Department of Primary Industries

OUT16/28538

Bulga Optimisation Project Modification 1 (SSD 4960 MOD 1) Comment on the exhibition of the Environmental Assessment

FIGURE 2.4
Alluvial Aquifers

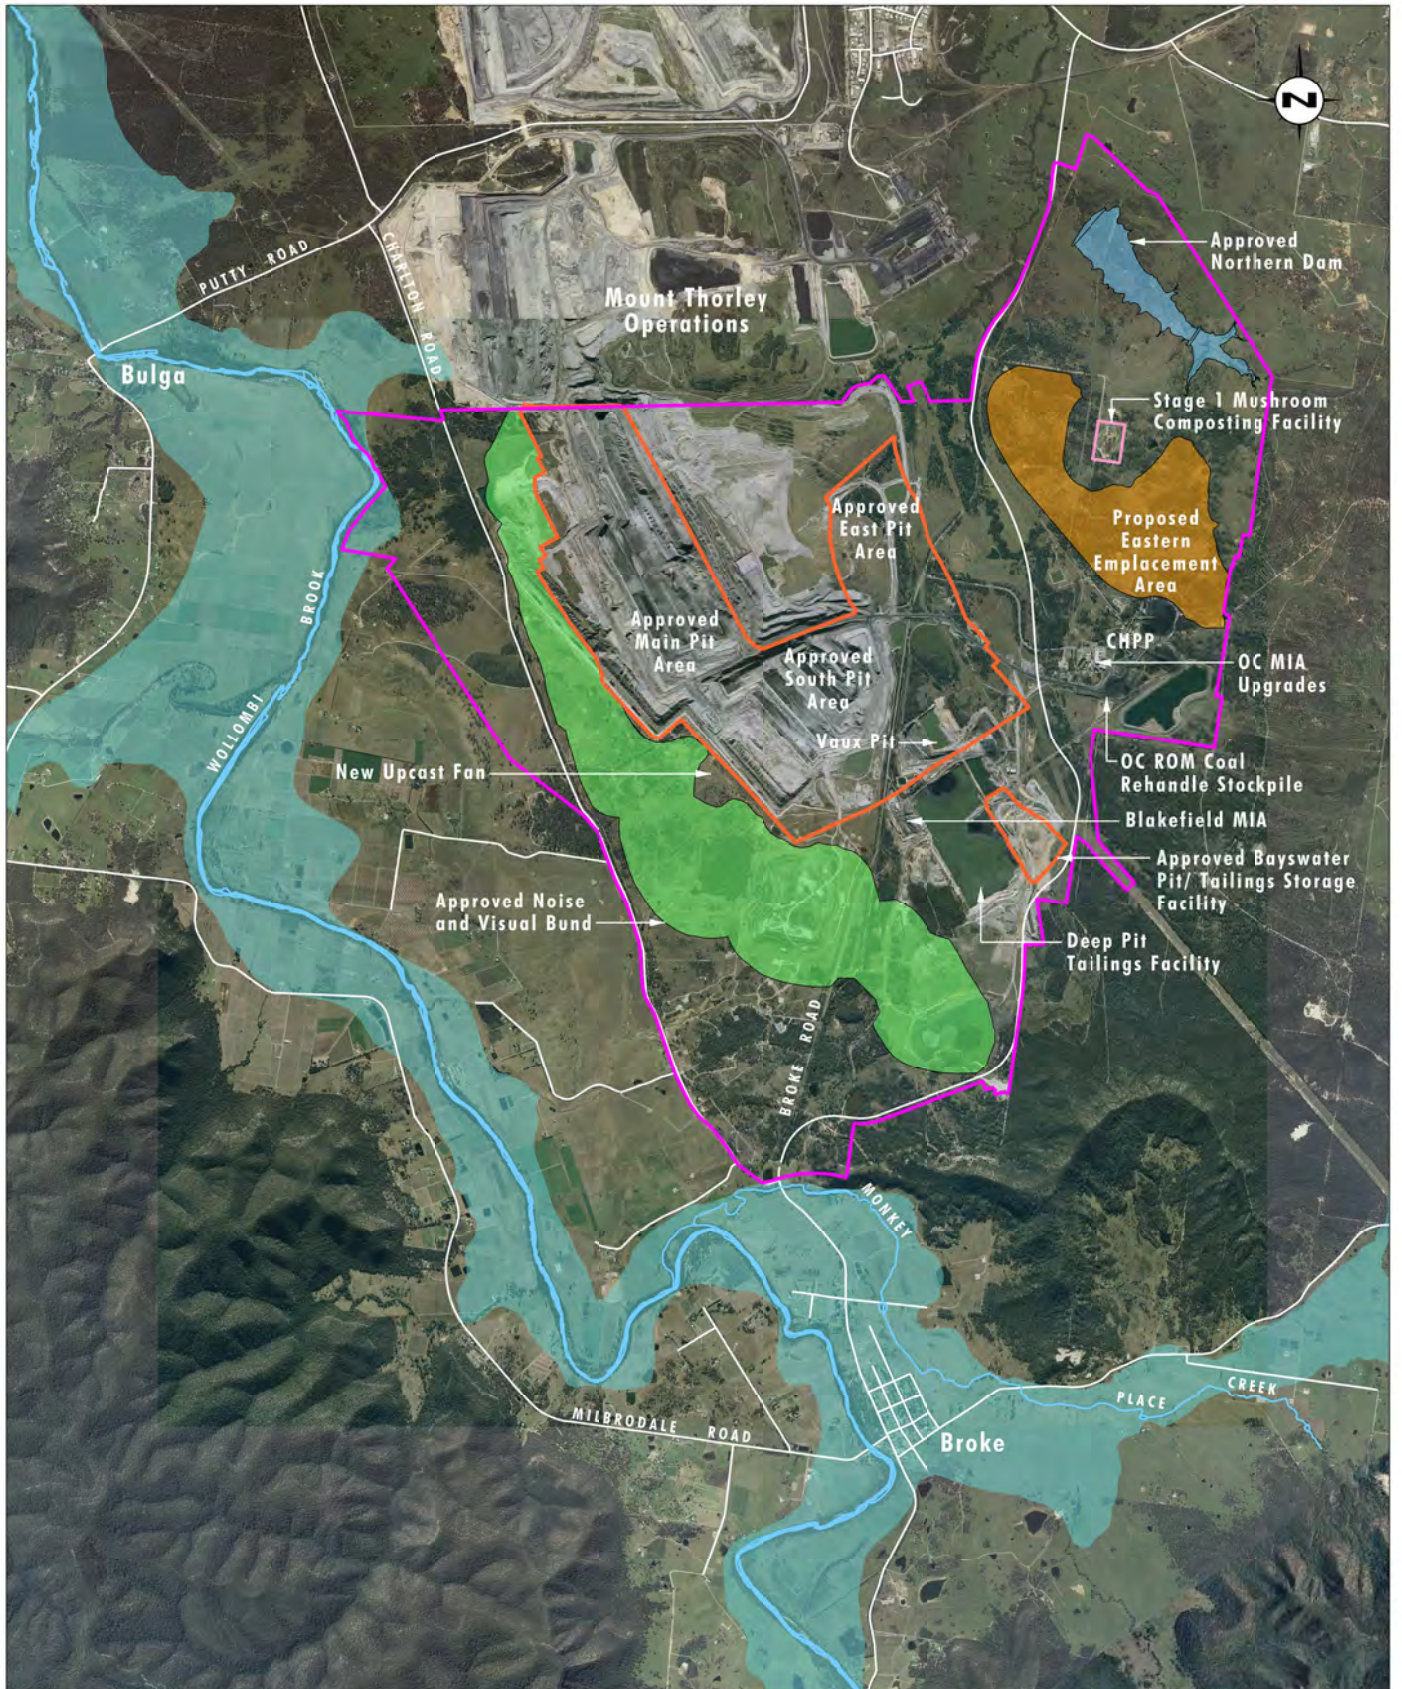
It is also requested that the proponent provides a map to demonstrate that the emplacement area doesn't overlie highly productive alluvial aquifers. Should this indicate

that emplacement is proposed over highly productive aquifers, further information and review will be required consistent with the NSW Aquifer Interference Policy.
